# Department for Transport

### **Application by Highways England (“the Applicant”) for an Order granting Development Consent for the A303 Sparkford to Ilchester Dualling.**

#### **REQUEST FOR COMMENTS FROM THE APPLICANT AND OTHER ADDRESSEES ON THE APPLICATION FOR THE PROPOSED A303 SPARKFORD TO IICHESTER DUALLING.**

Drawing Title
**FIGURE 11.4
NOISE LEVELS IN THE DO MINIMUM DESIGN YEAR
LA10, 18HR [dB] - SHEET 1 OF 4**

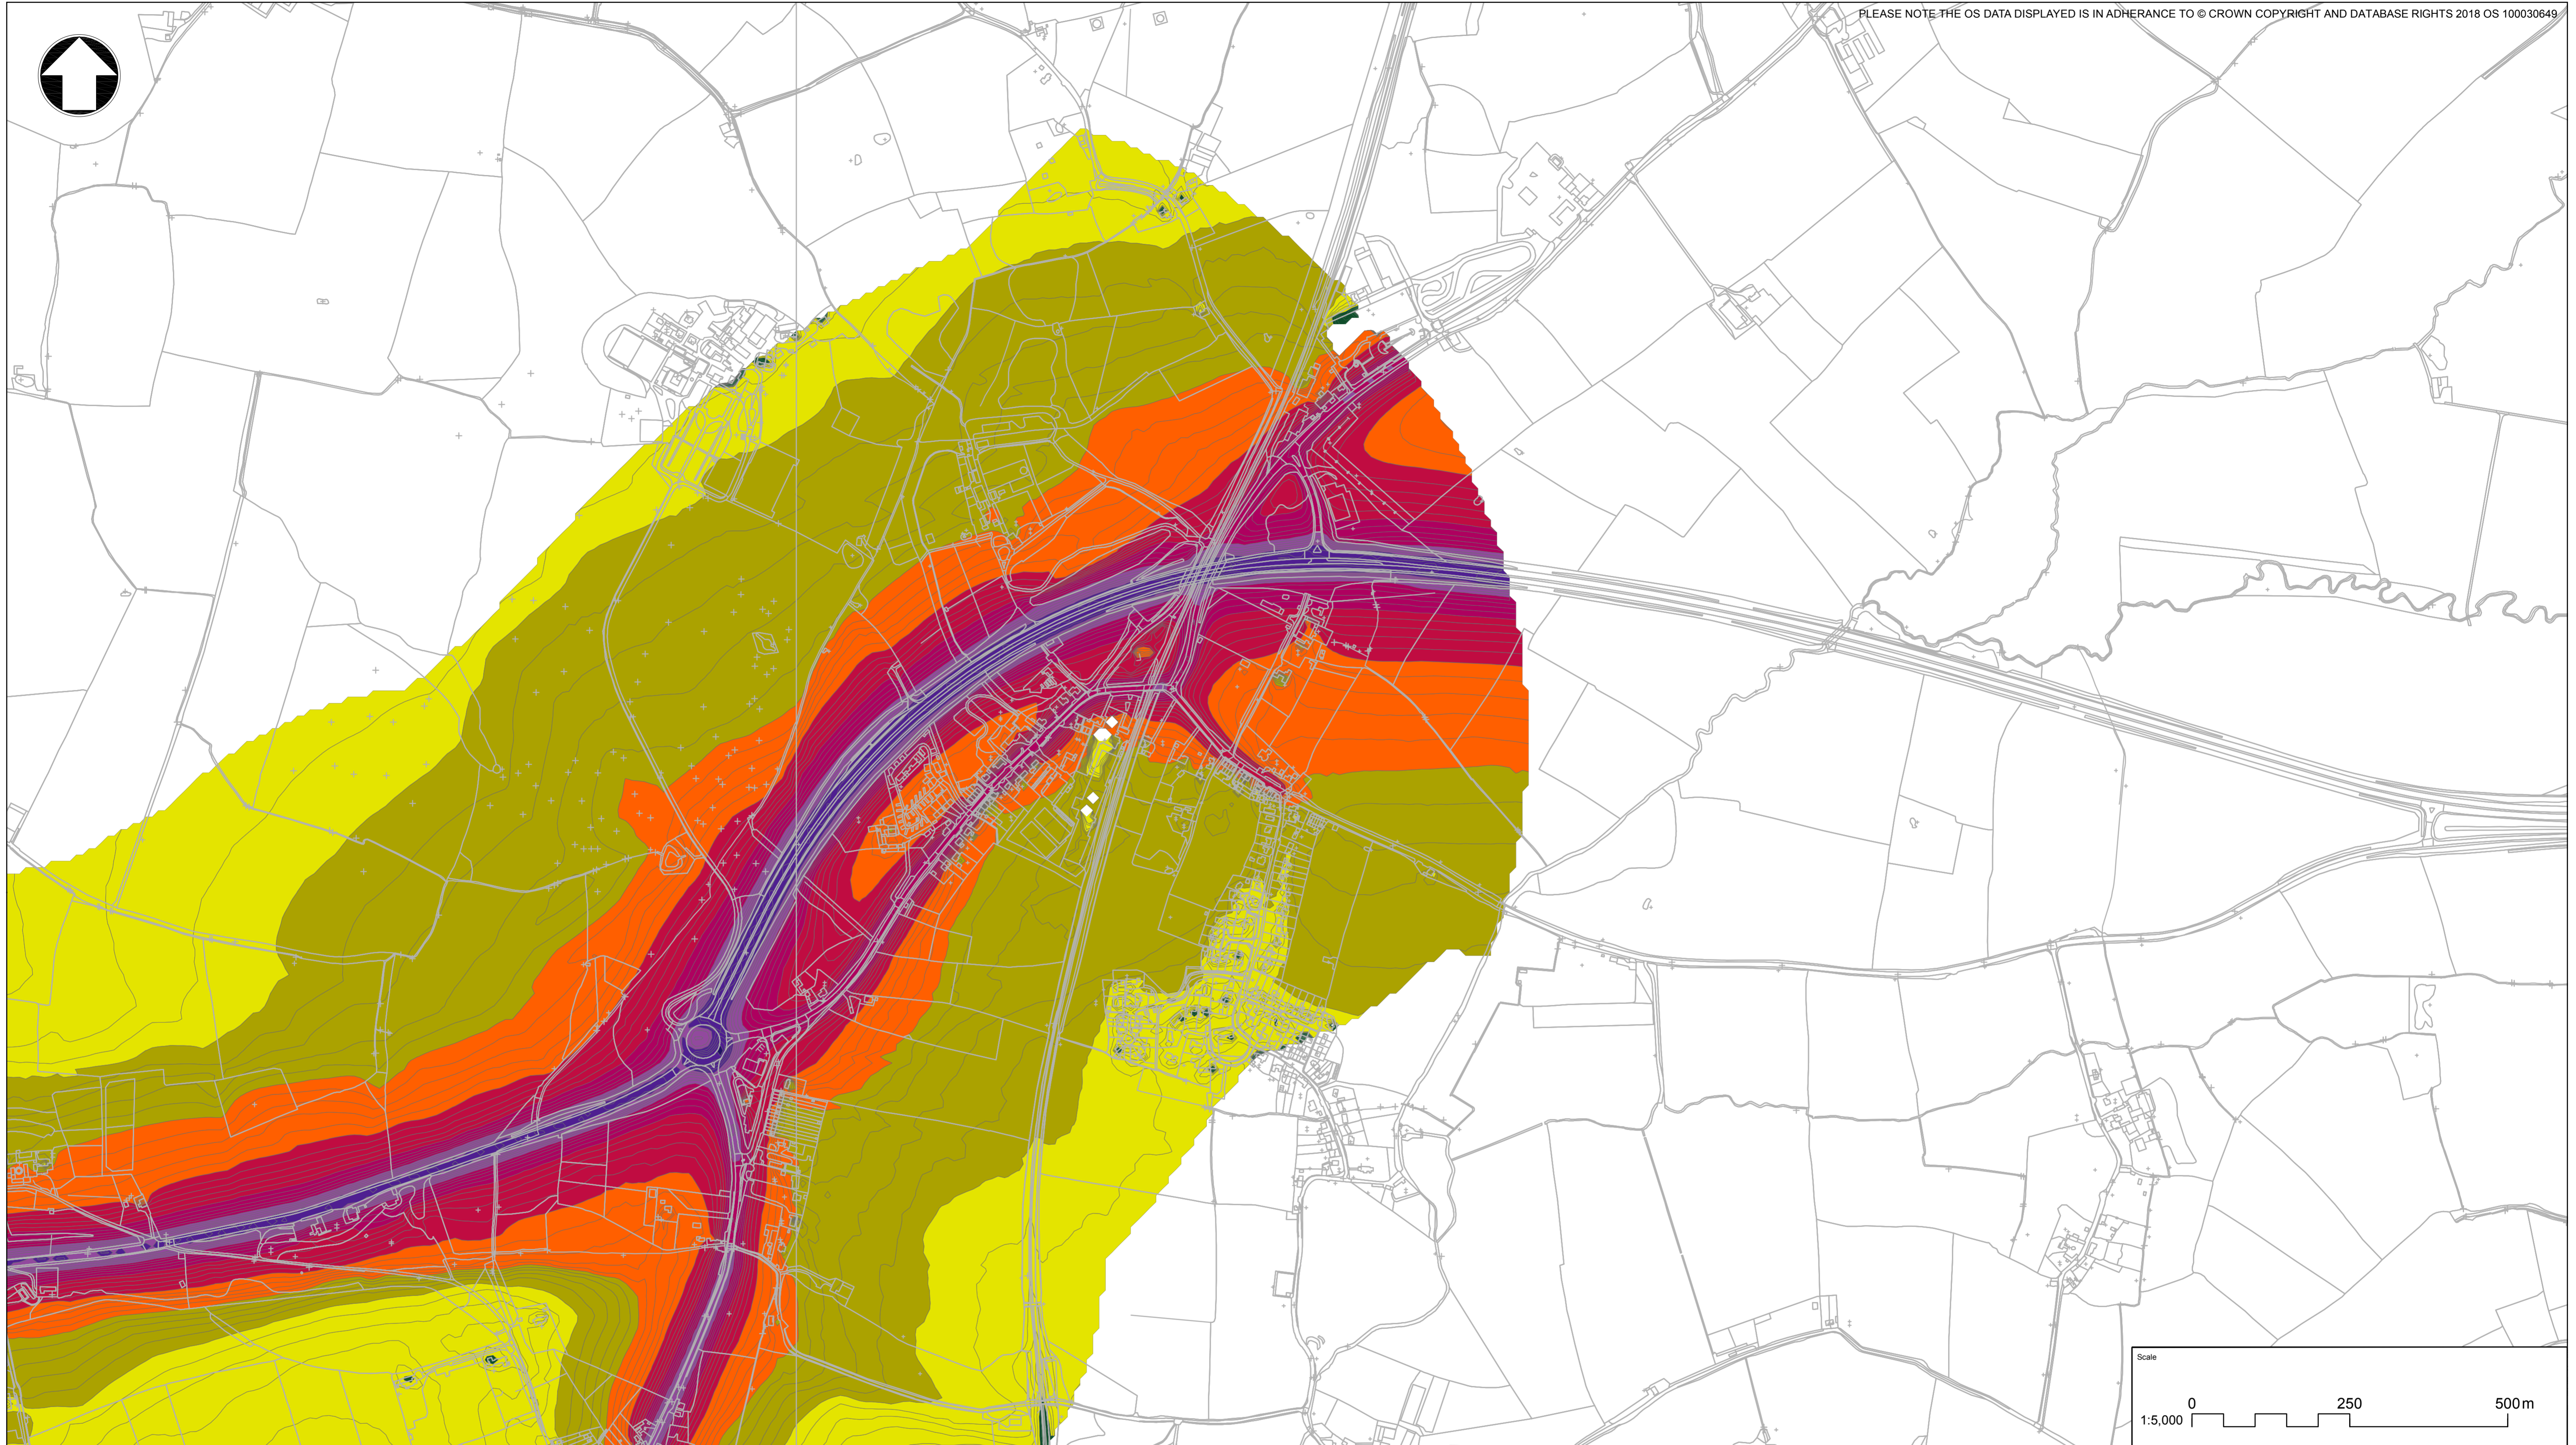
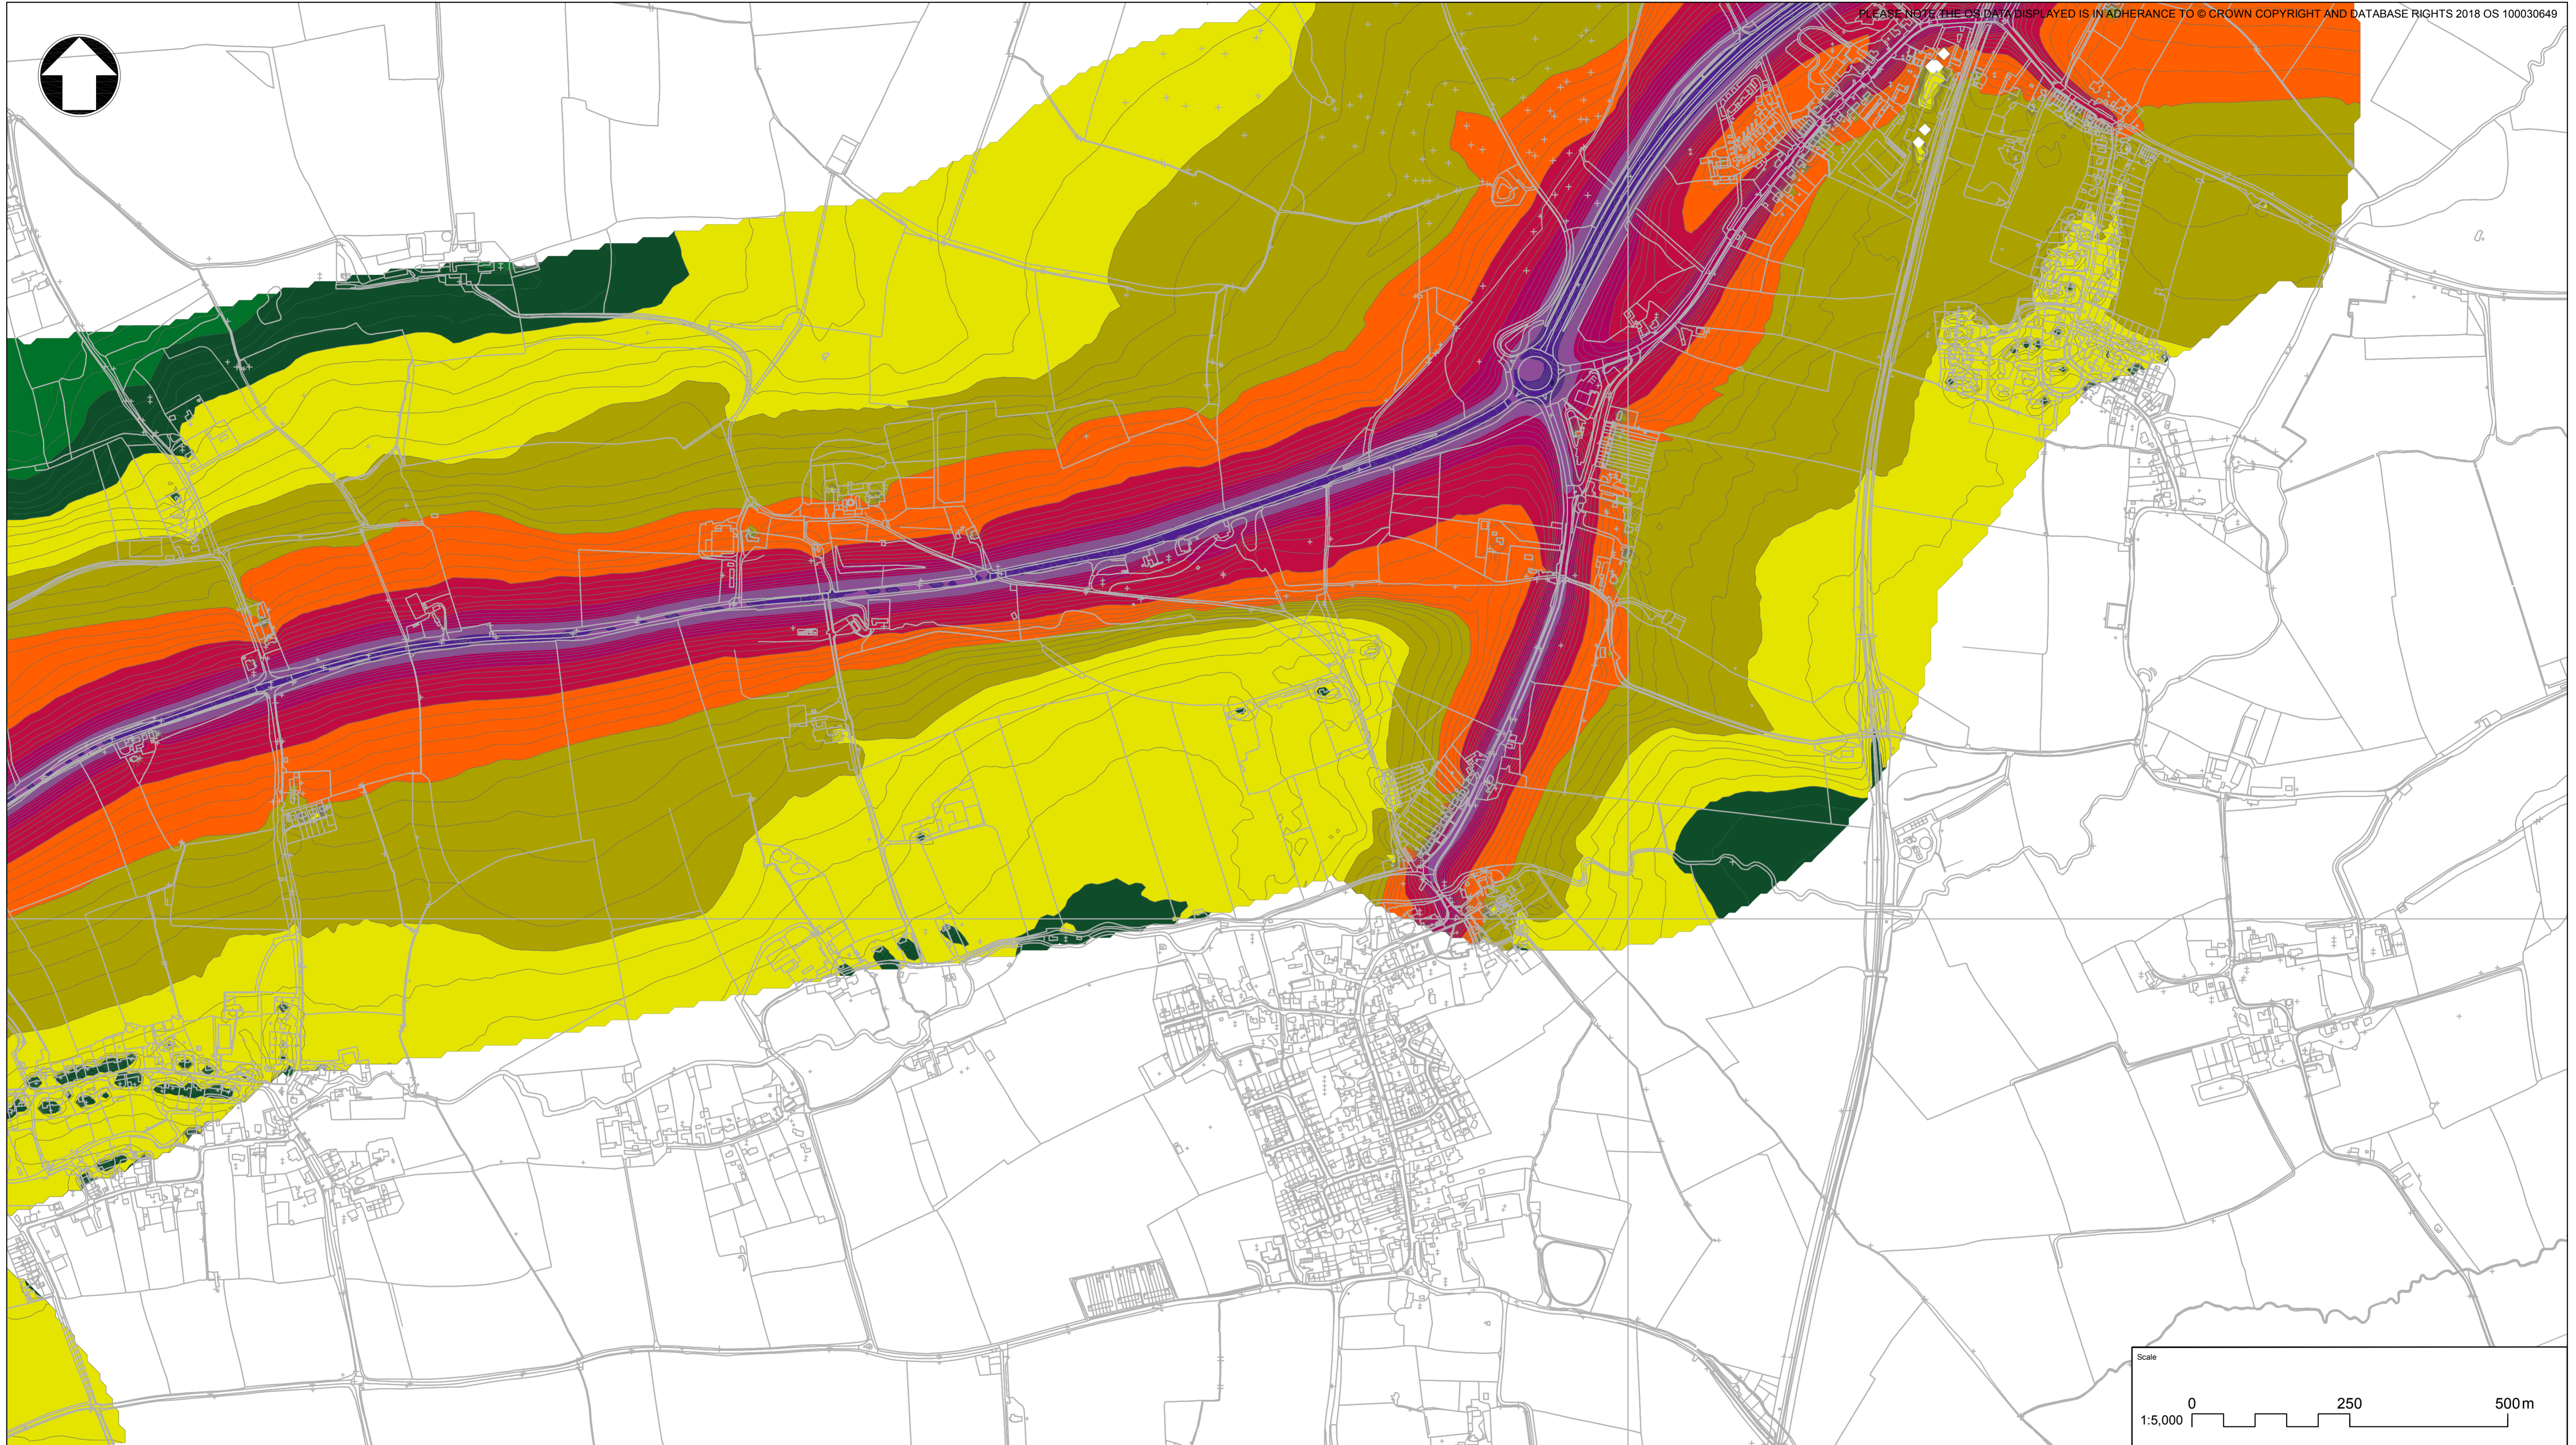
The Secretary of State invites the Applicant to provide further evidence that residential receptors, in particular, the consented residential development at Long Hazel Park and Sparkford High Street, would not be subject to a Significant Observed Adverse Effect Level (“SOAEL”) in accordance with the Noise Policy Statement for England, including details of any mitigation measures necessary to achieve this.
